October 25, 2017

RE: **Bosque Brewery**
I-25 west Frontage Rd between Venice & Pasadena
Conceptual Grading and Drainage Report
Stamp Date: 10/24/17
Hydrology File: B18D022

Based upon the information provided in your submittal received 10/24/17, the above referenced submittal cannot be approved for Site Plan for Building Permit or Building Permit until the following comments are addressed:

FRENCH DRAIN W/PUMP DETAIL

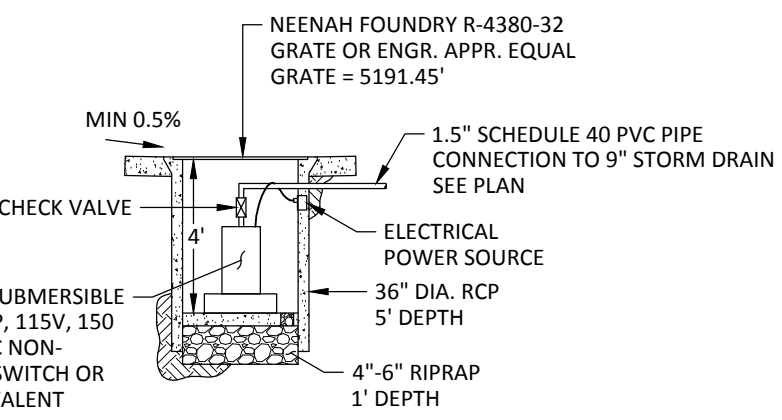
6. Recommendation: The French drain for subbasin 1.1 appears to only be able to hold 35CF; whereas the first flush volume is 98CF and the 100year, day volume is 1338CF. Please provide additional retention volume to keep the loading dock usable. Additionally this design seems susceptible to clogging and will be maintenance intensive.

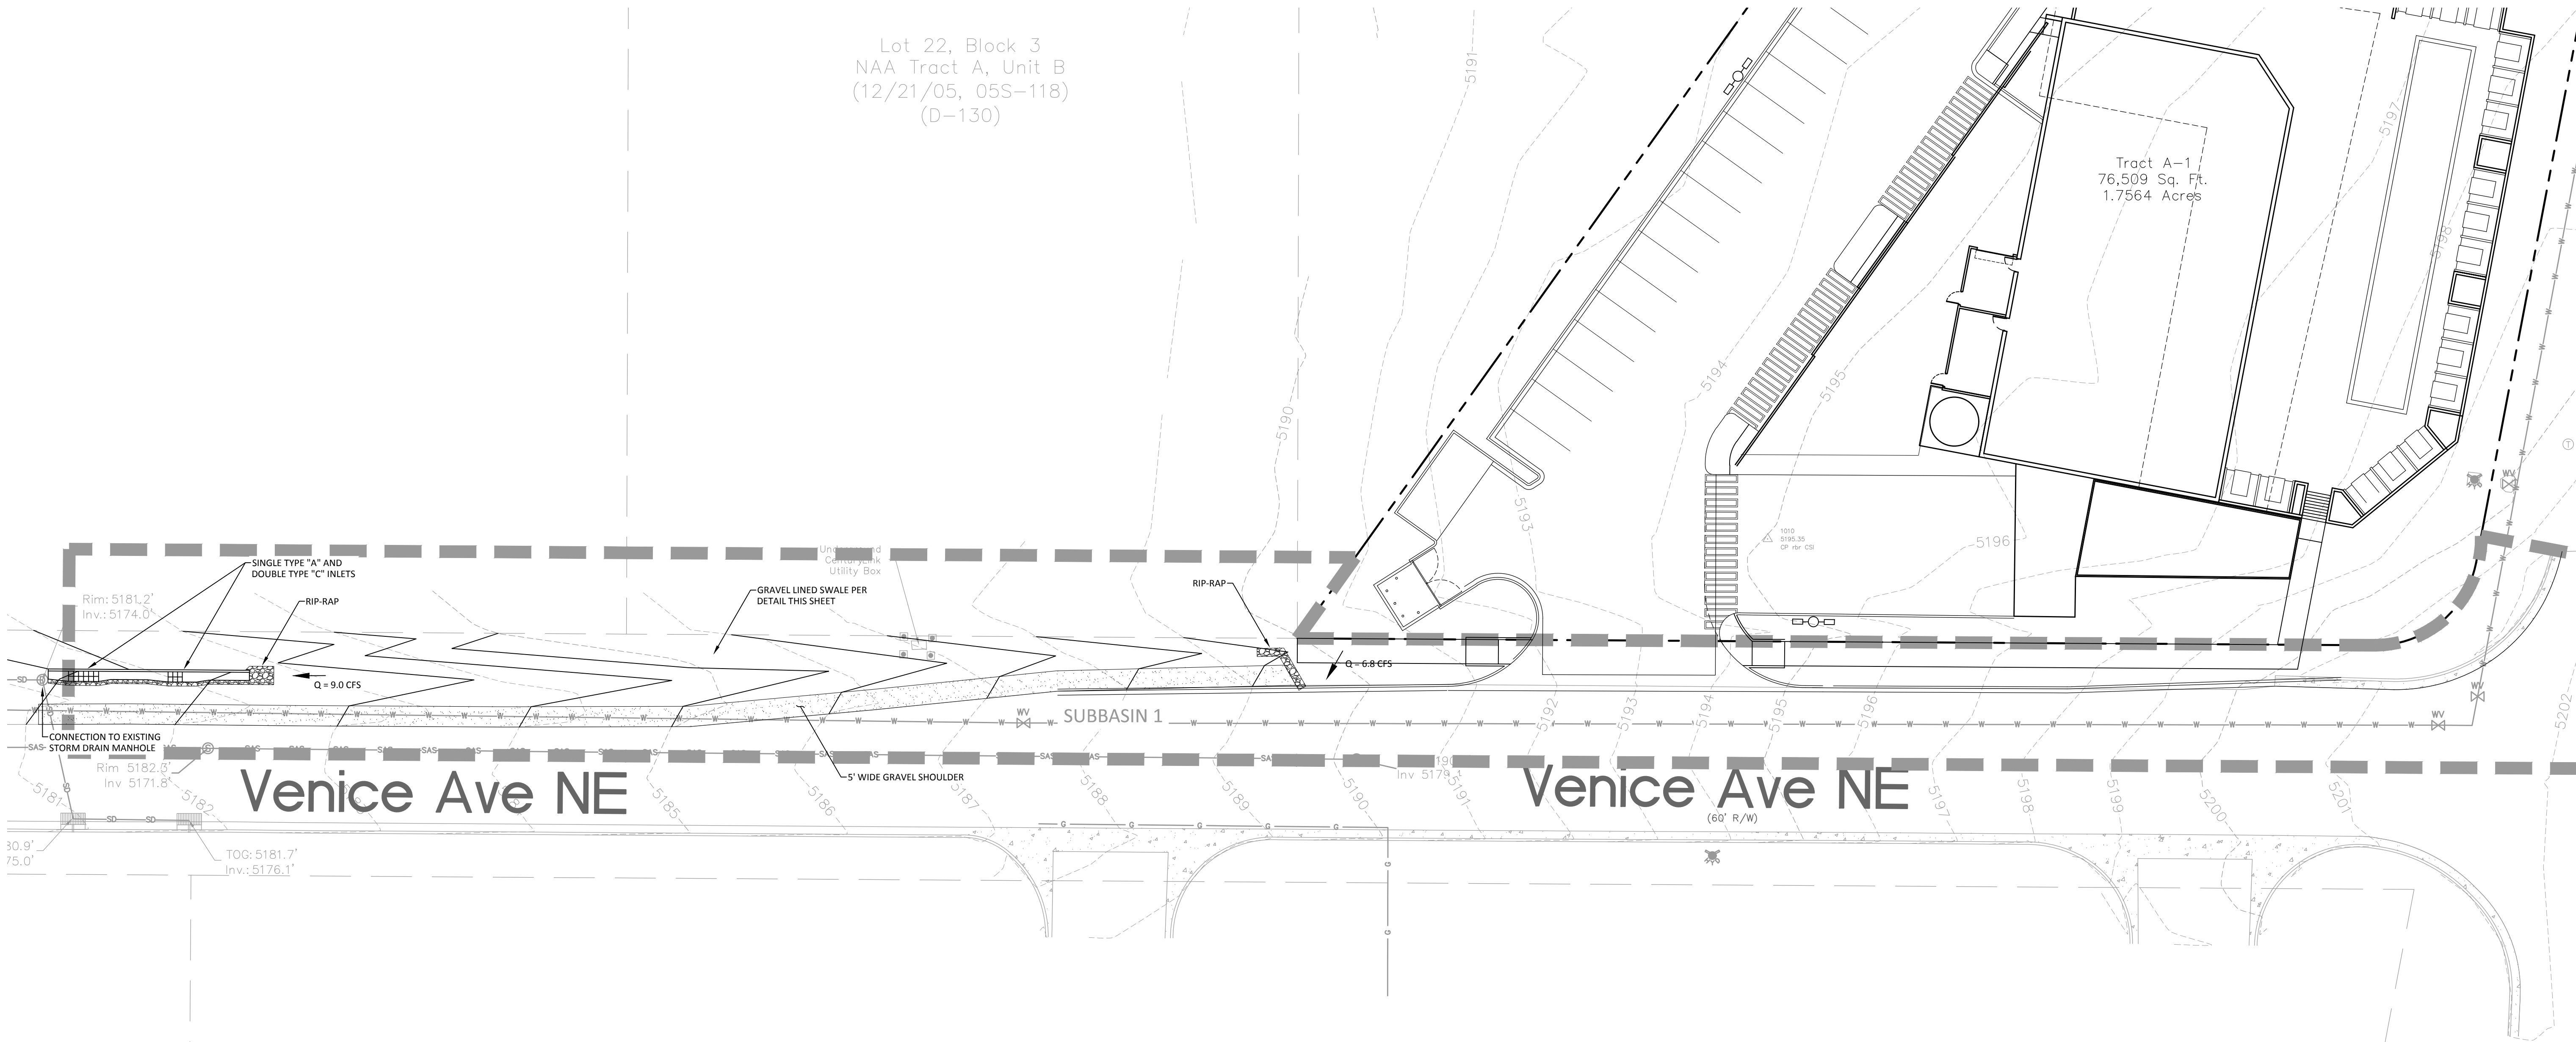
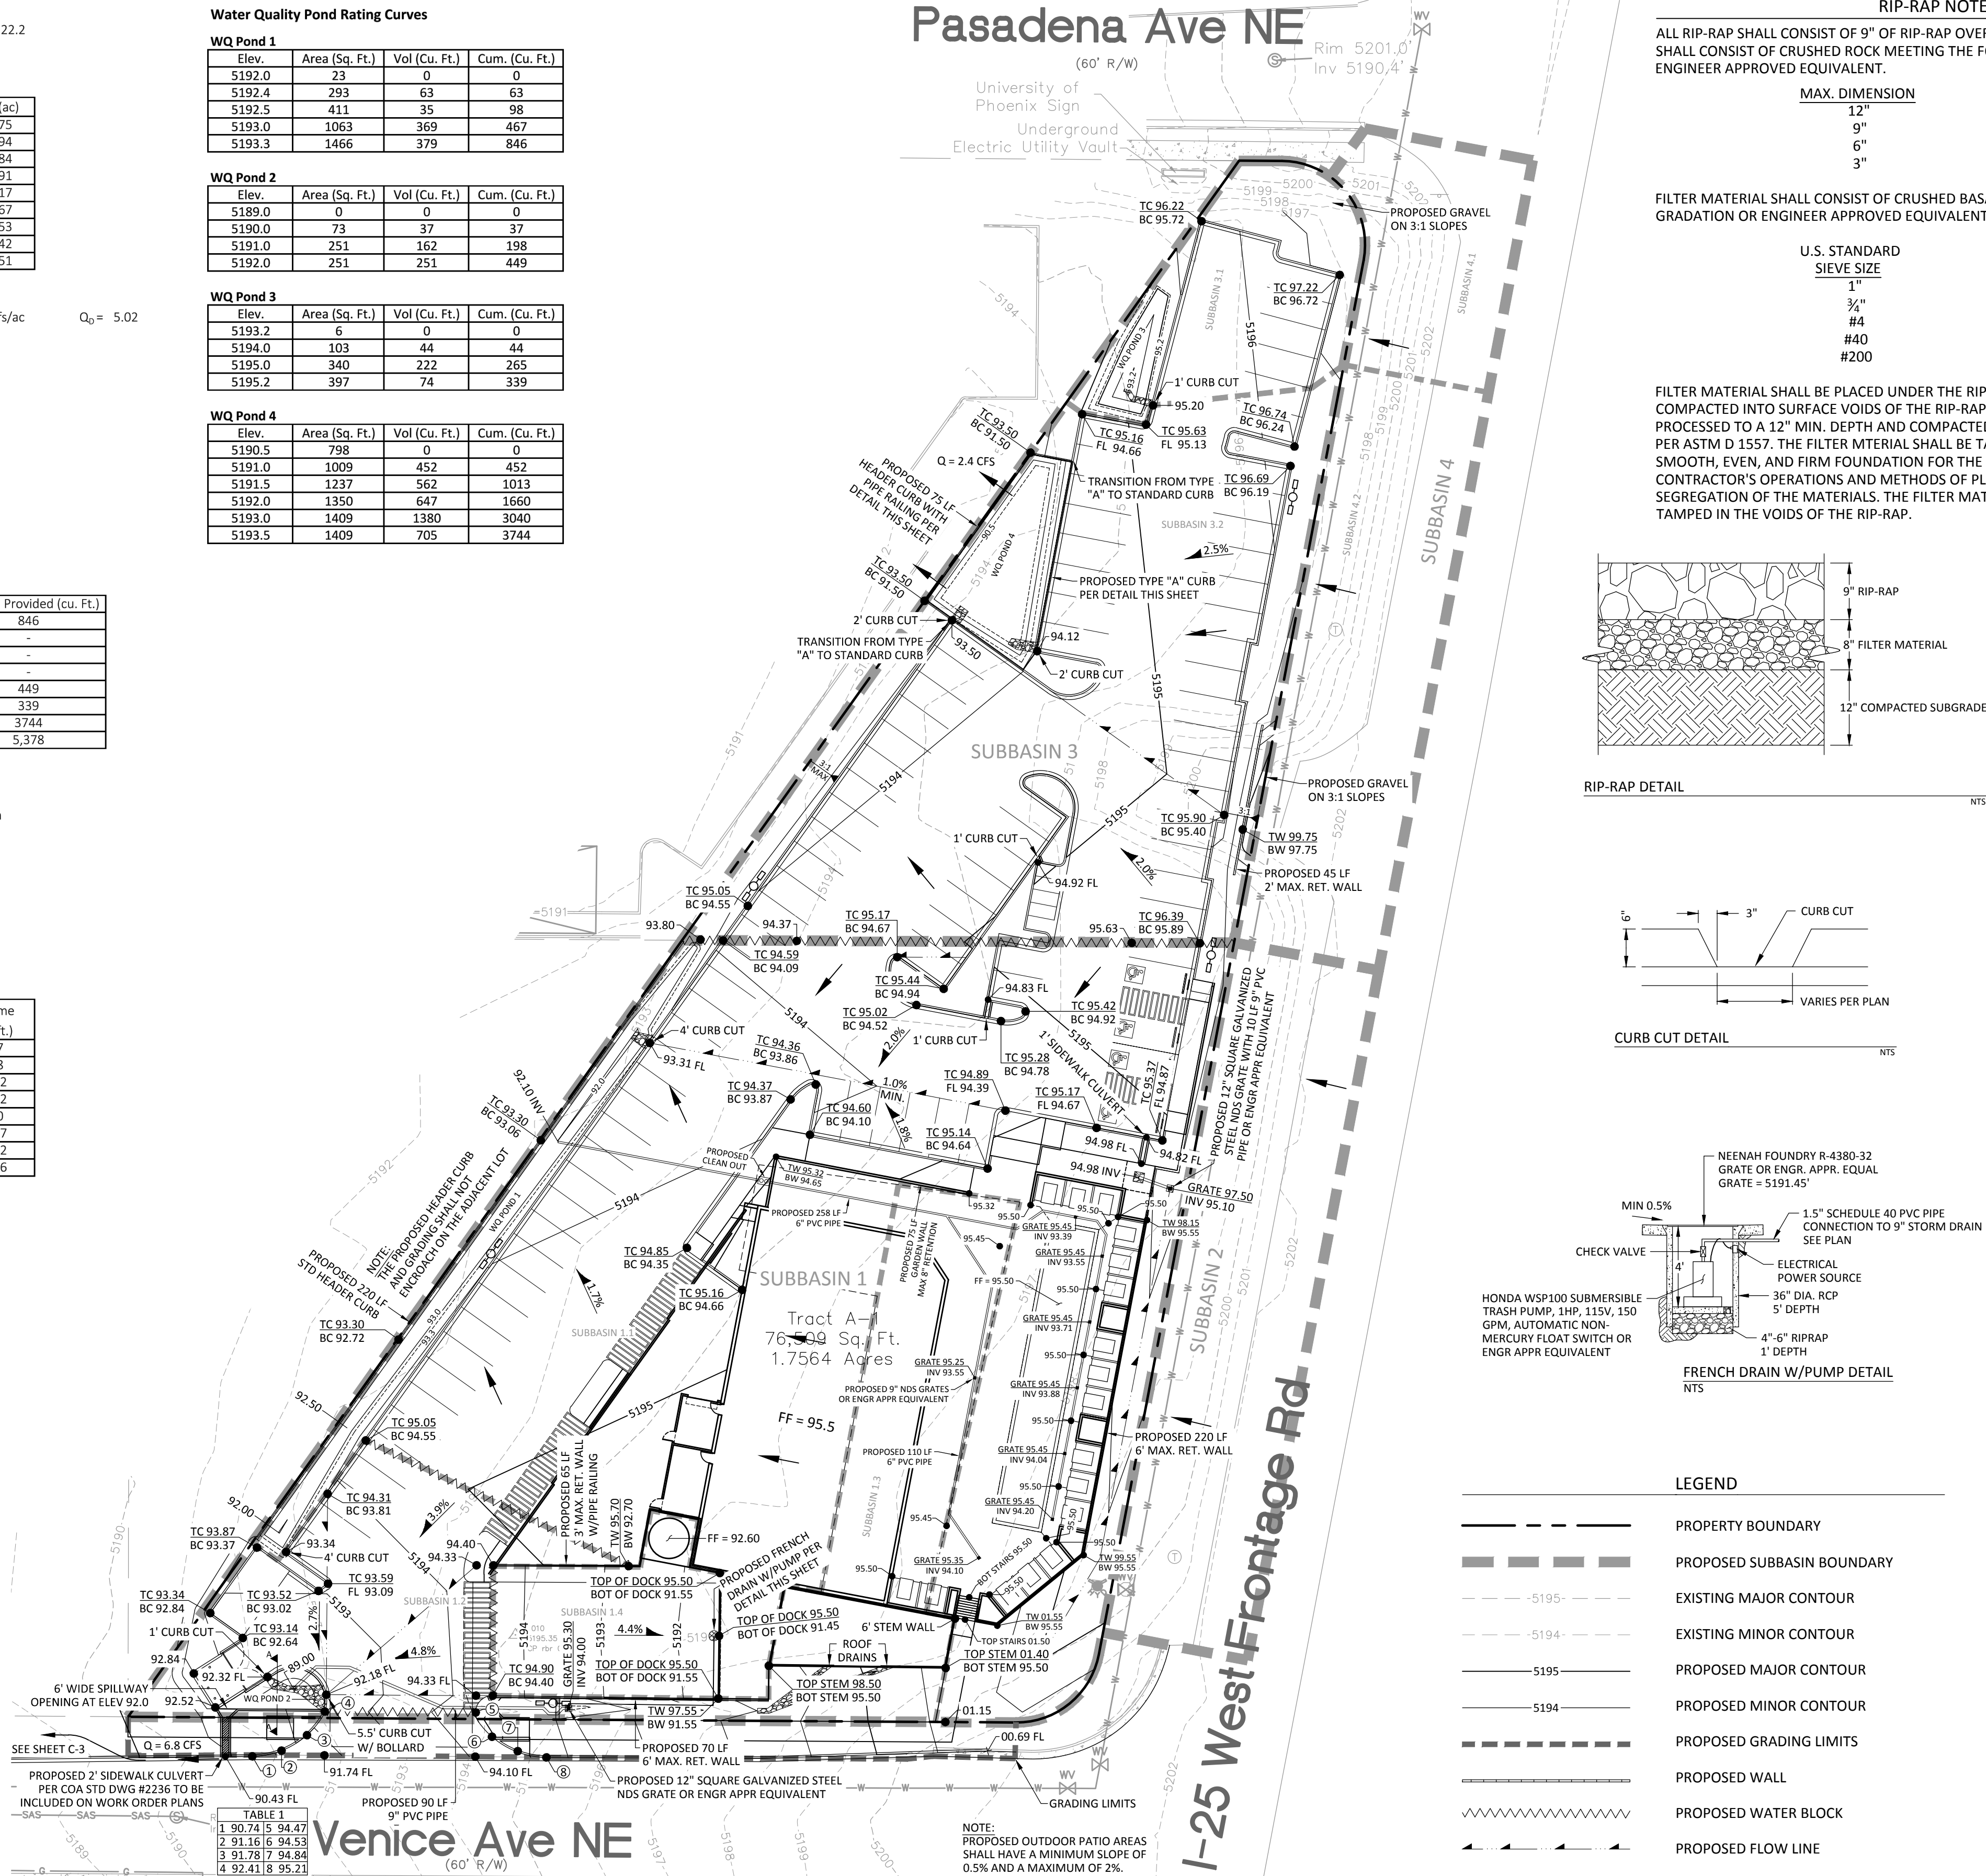
2. Separate subbasin 1 into 2 subbasins, showing what first flush volume flows to WQ Pond 1 vs. WQ Pond 2. Each pond needs to be large enough to retain the first flush volume for its subbasin.

3. WQ Pond 3 needs to be increased to retain 150CF. Alternatively, Fee-in-Lieu may be made for the bypass volume (\$8.00/CF x 4CF) if no other options are available.

4. At the drop inlets on Venice, extend the riprap mattress around the gutter pans (between the gravel shoulder and the gutterpans.
5. At the drop inlets, include a berm or warp the grading to force the swale towards the inlets and keep higher flows from running behind back-of curb.
